Our ref: SSD-65924461

Subject: Request for Additional Information – Stephen Road Multi-level Warehouse,
Banksmeadow (SSD-65924461)

Attachment 1: The Department's comments on the Amendment Report

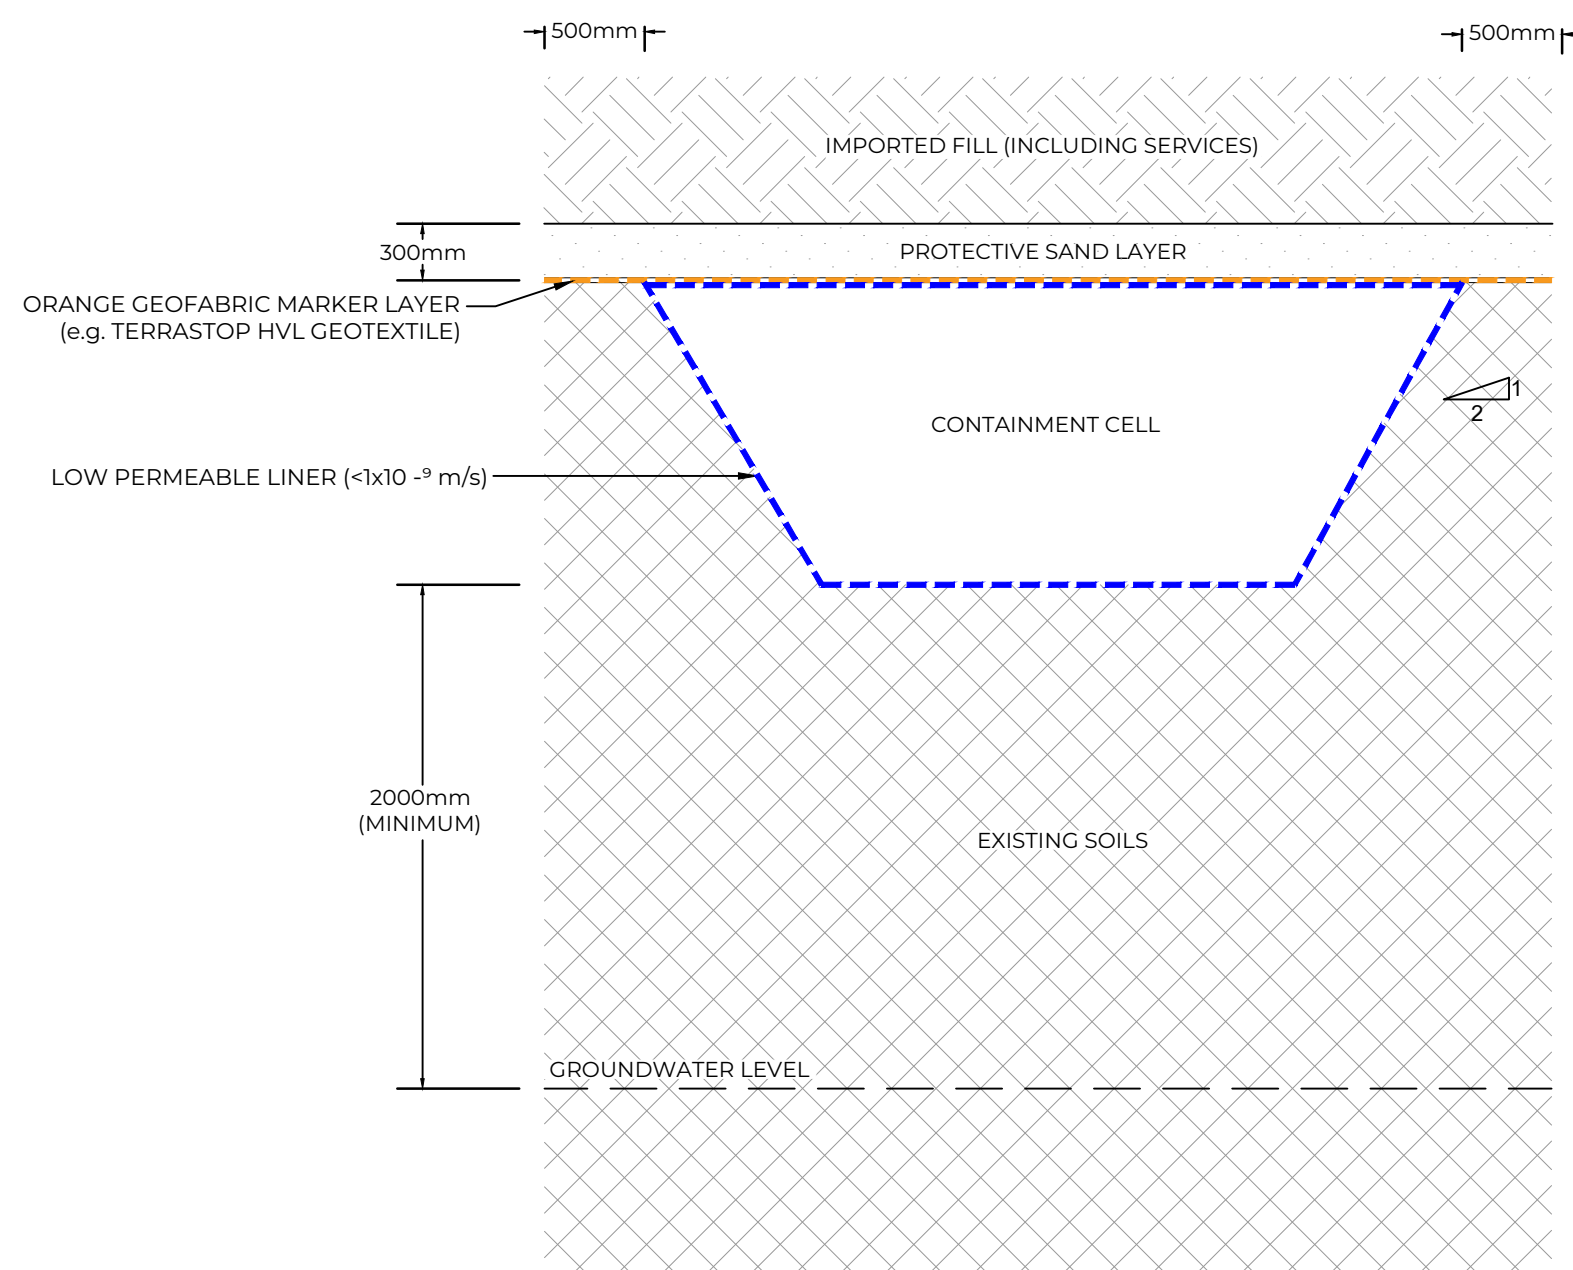
1. The Remedial Action Plan (RAP) proposes placing soils containing organochlorine pesticide concentrations exceeding the remediation criteria within a containment cell. Additional information is required to clearly define the location and design of the proposed containment cell, its relationship to the overall development, and to provide written interim advice from the Site Auditor confirming acceptance of this approach.

DA10.01 8

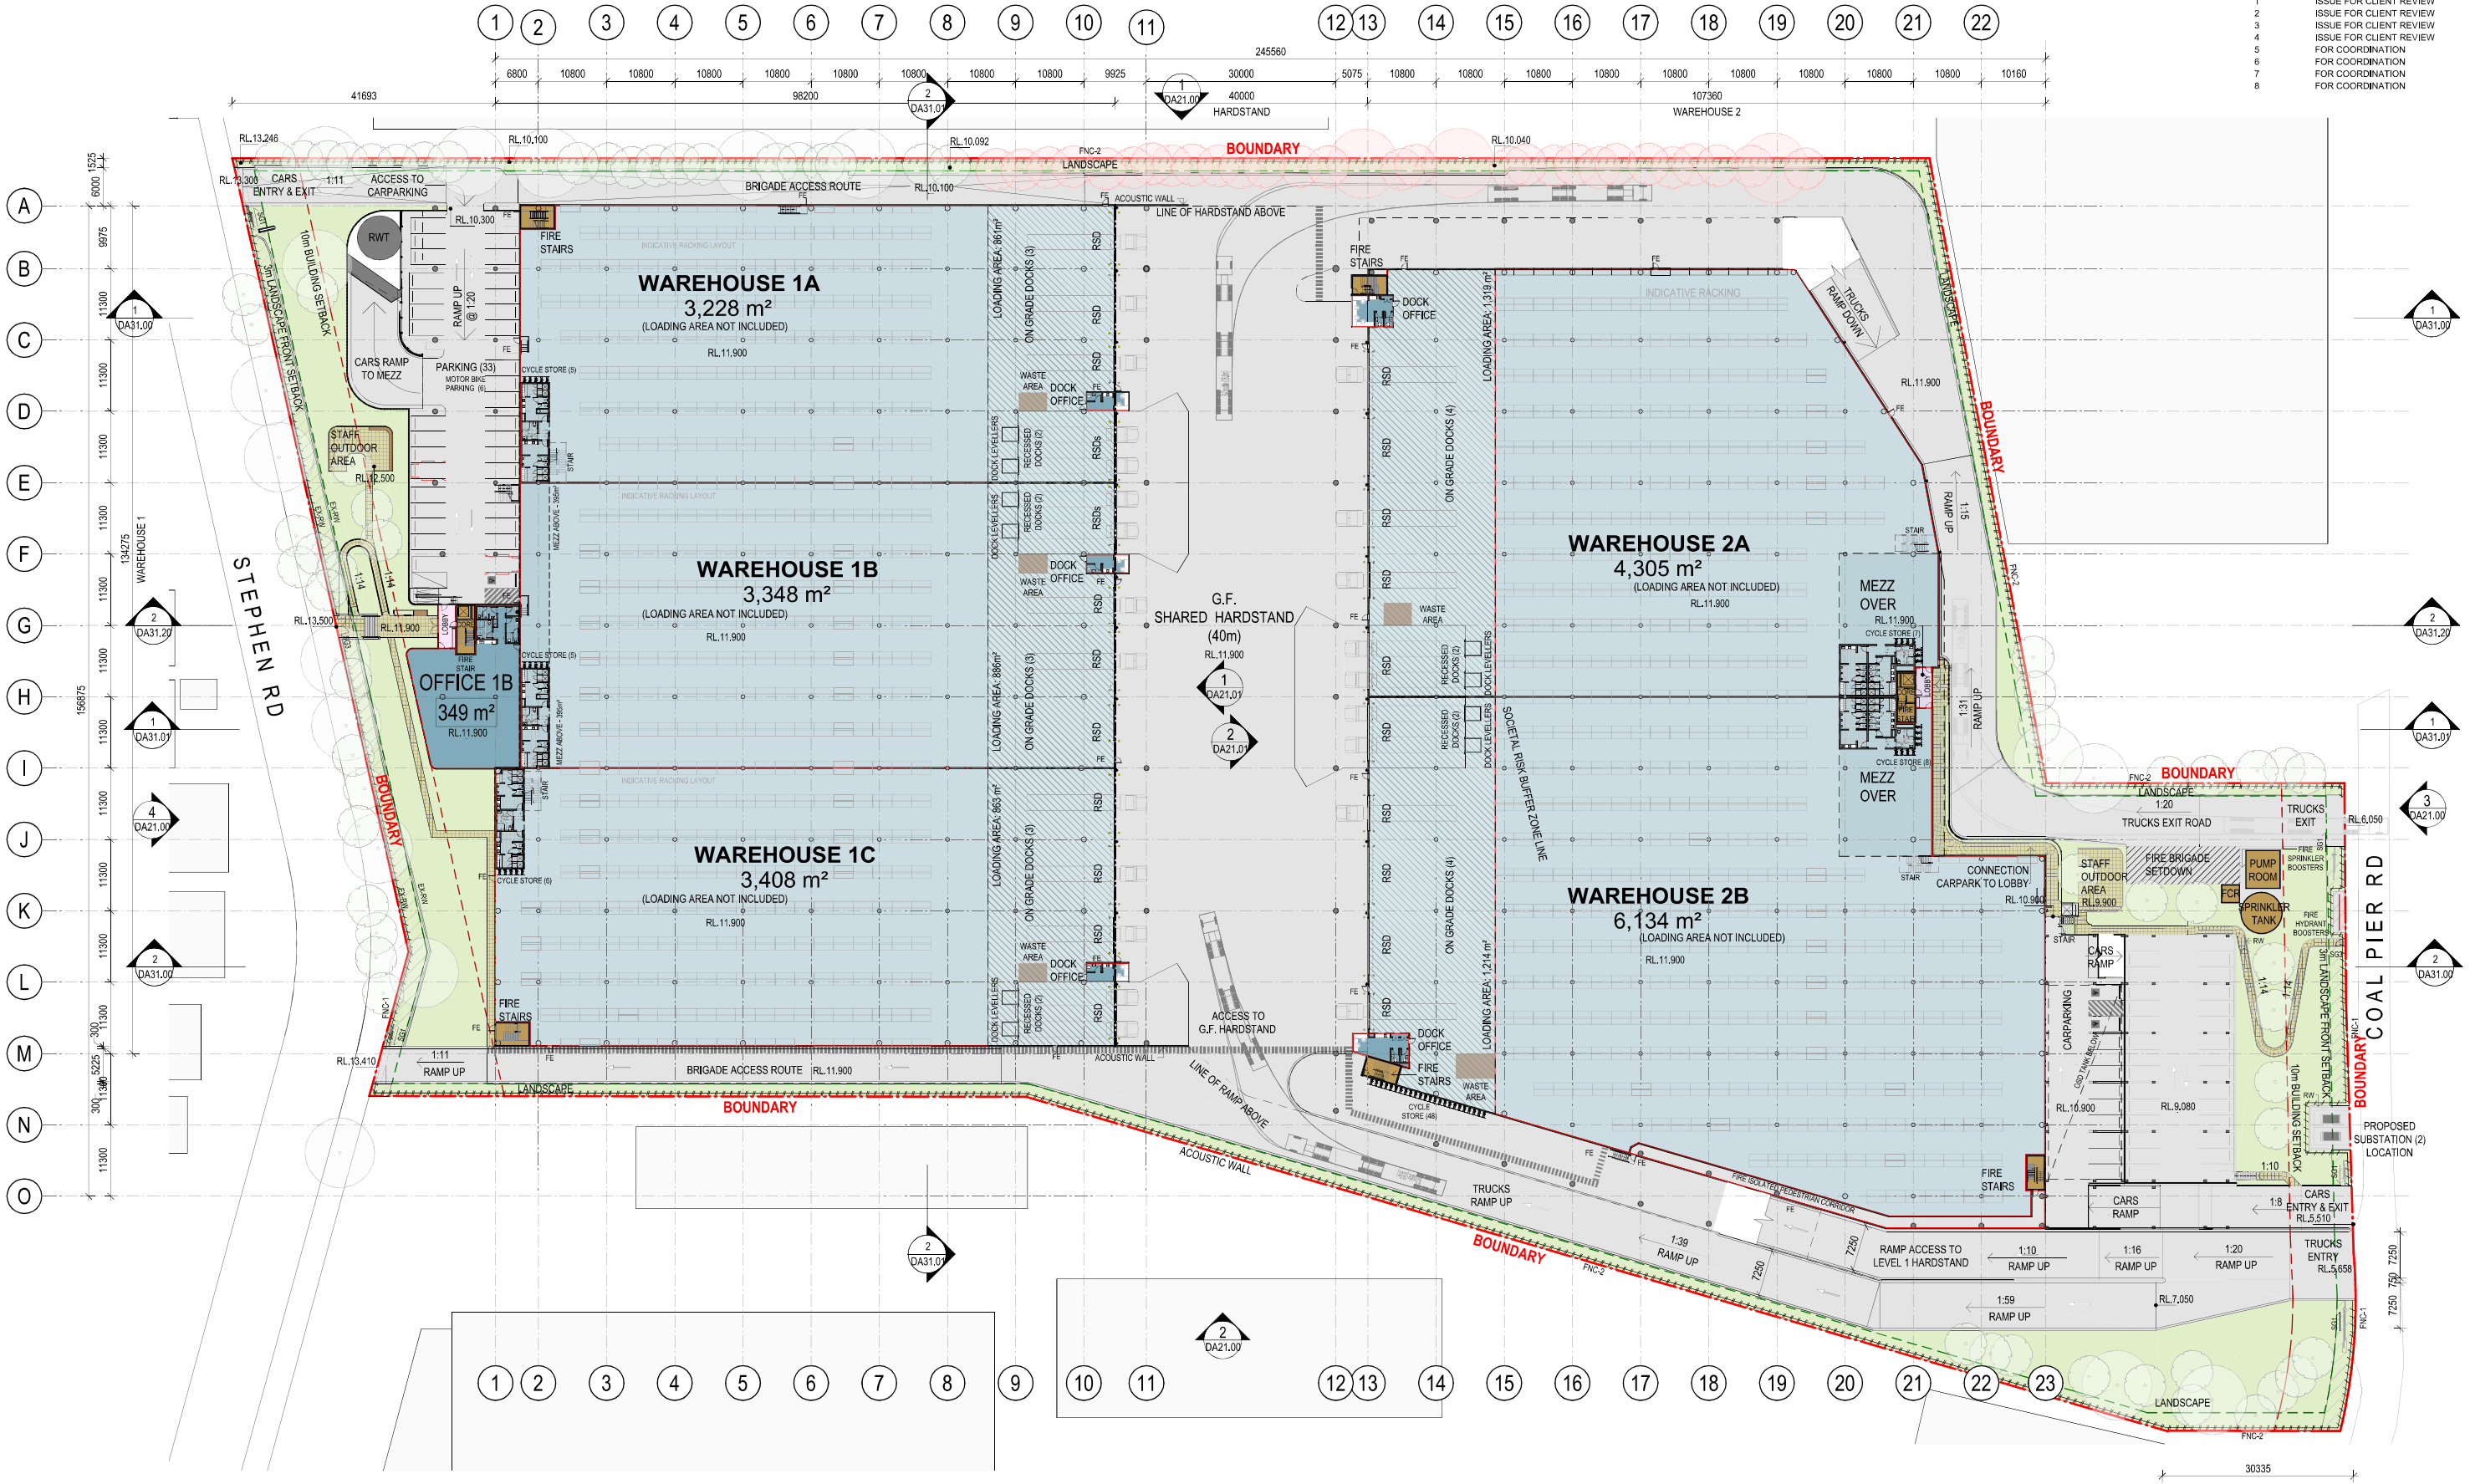
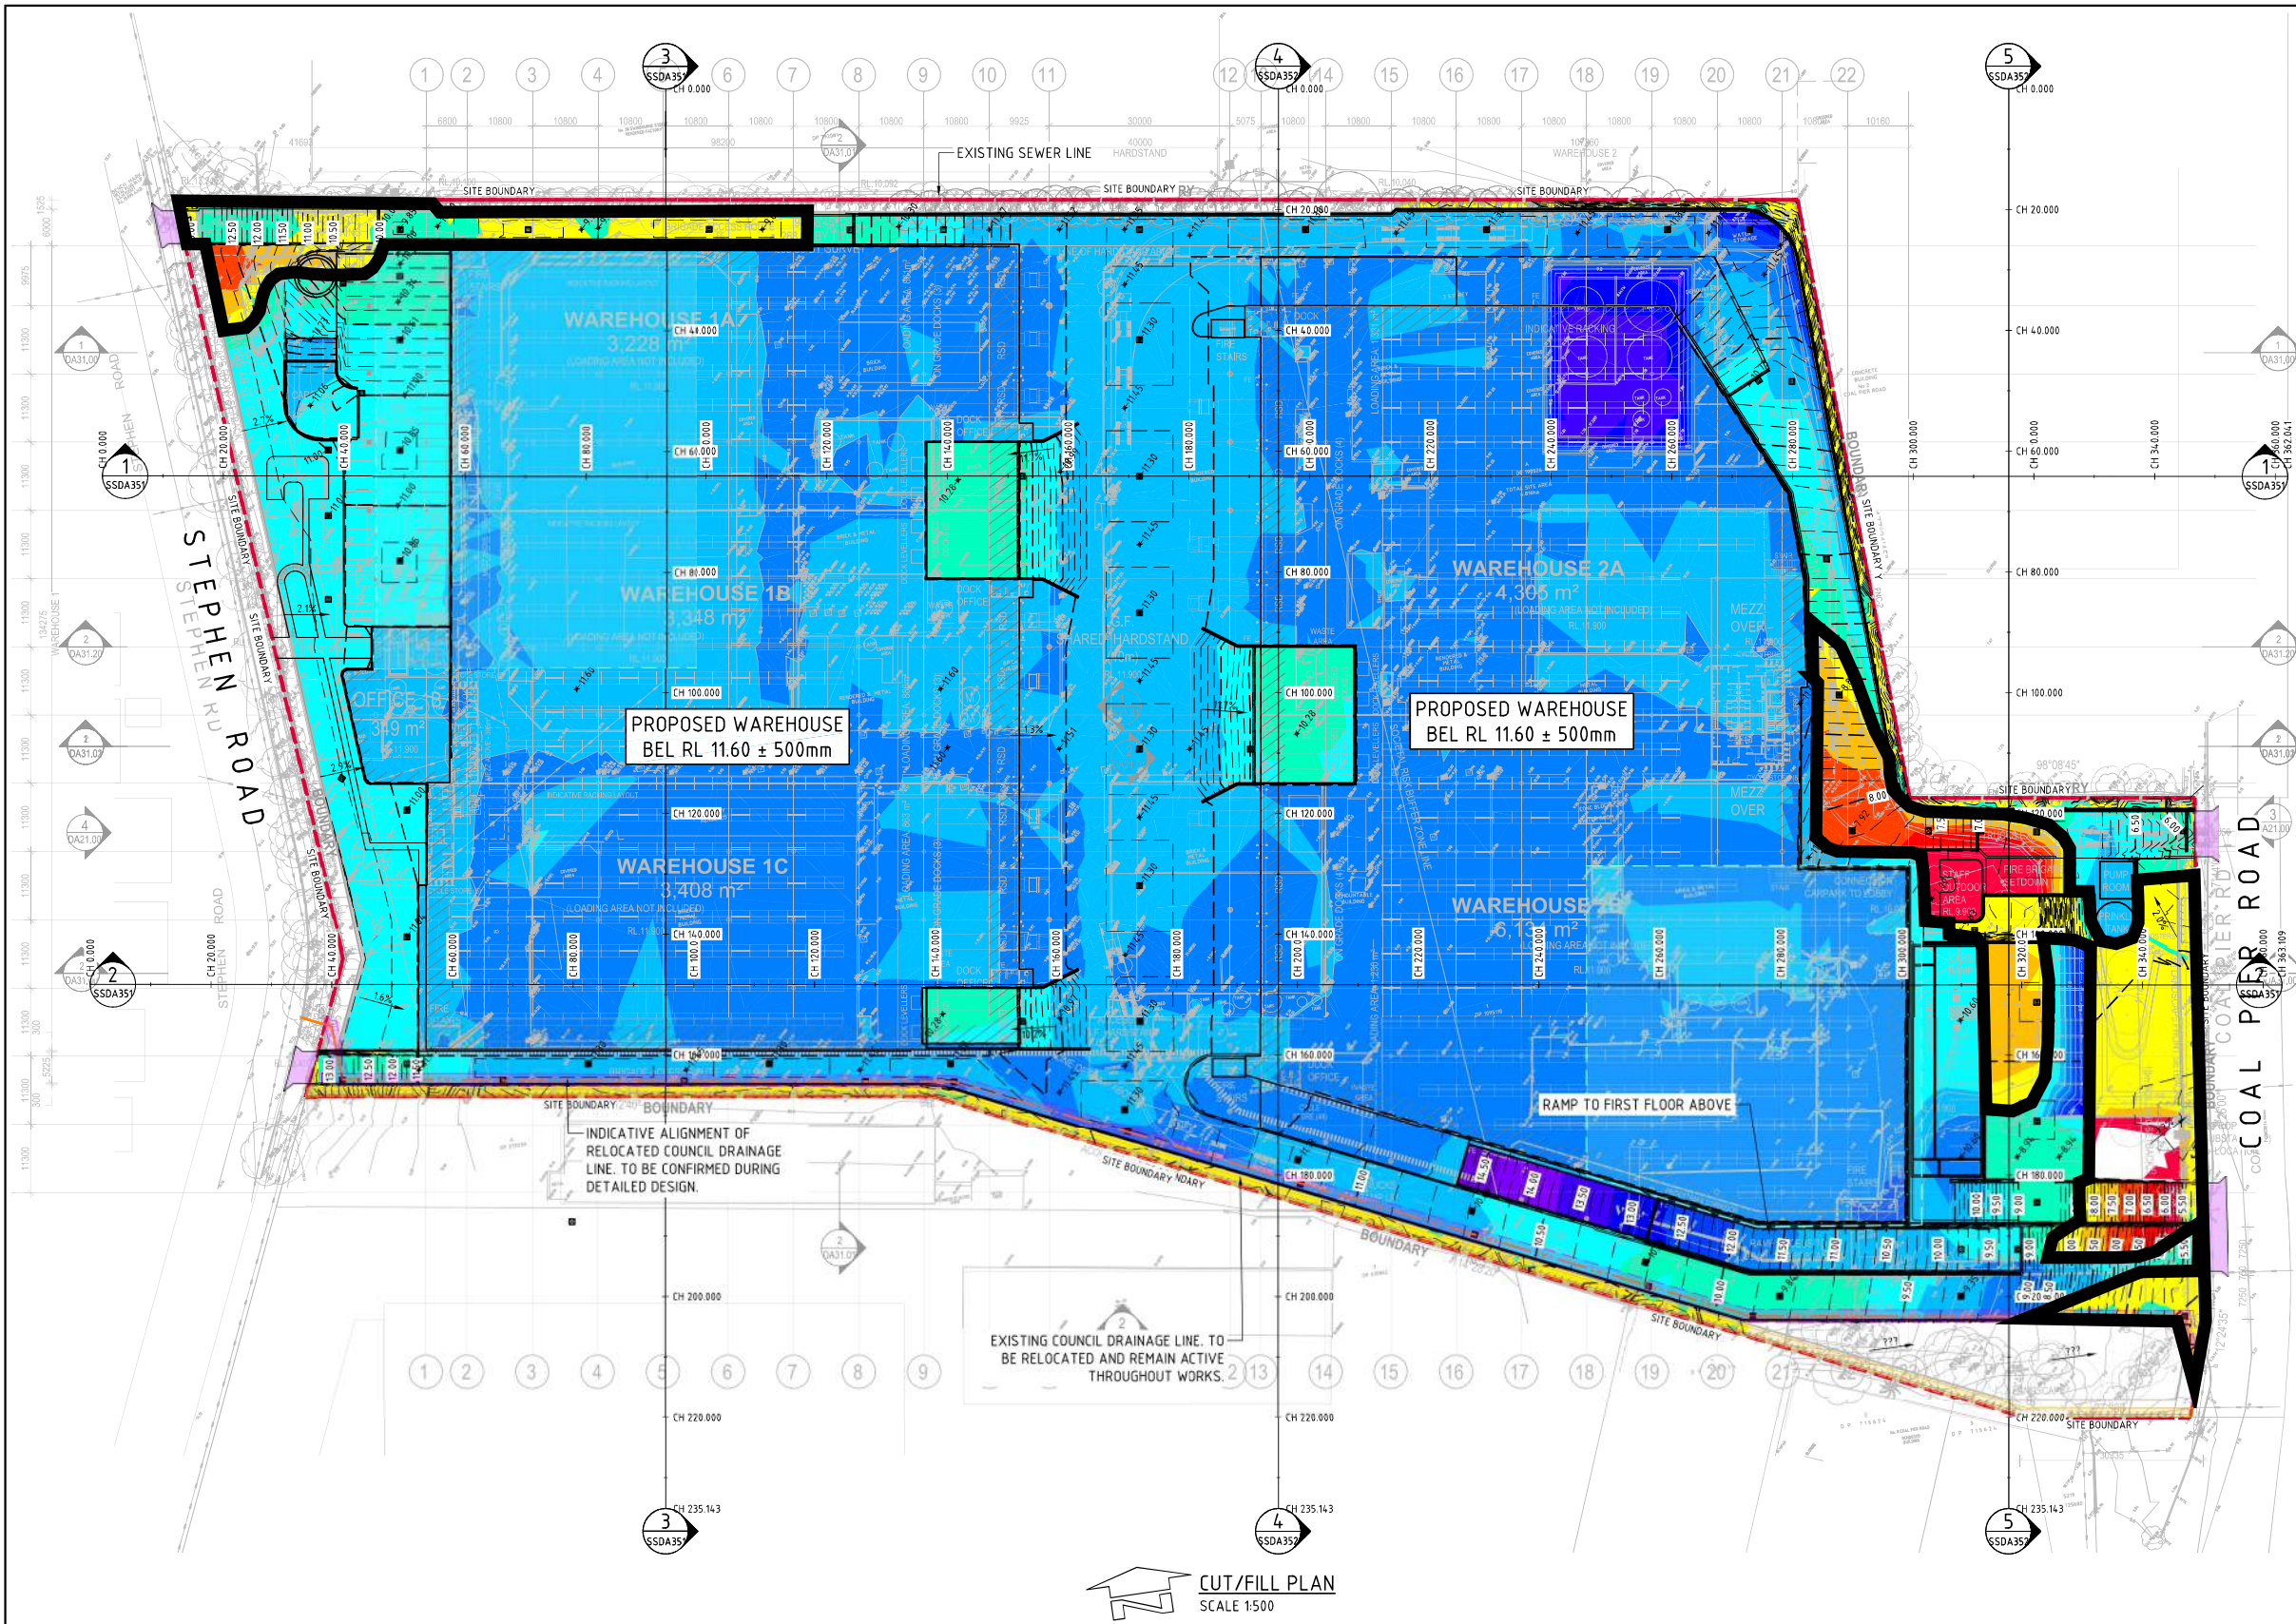
13. The number of trees shown to be removed in the Arborist Report tree protection plan and architectural drawing DA10.00 are inconsistent and are to be clarified. Please ensure all documentation (Landscape Plan, Architectural Plan and Arborist Report) is consistent with regard to the number of trees proposed to be removed.
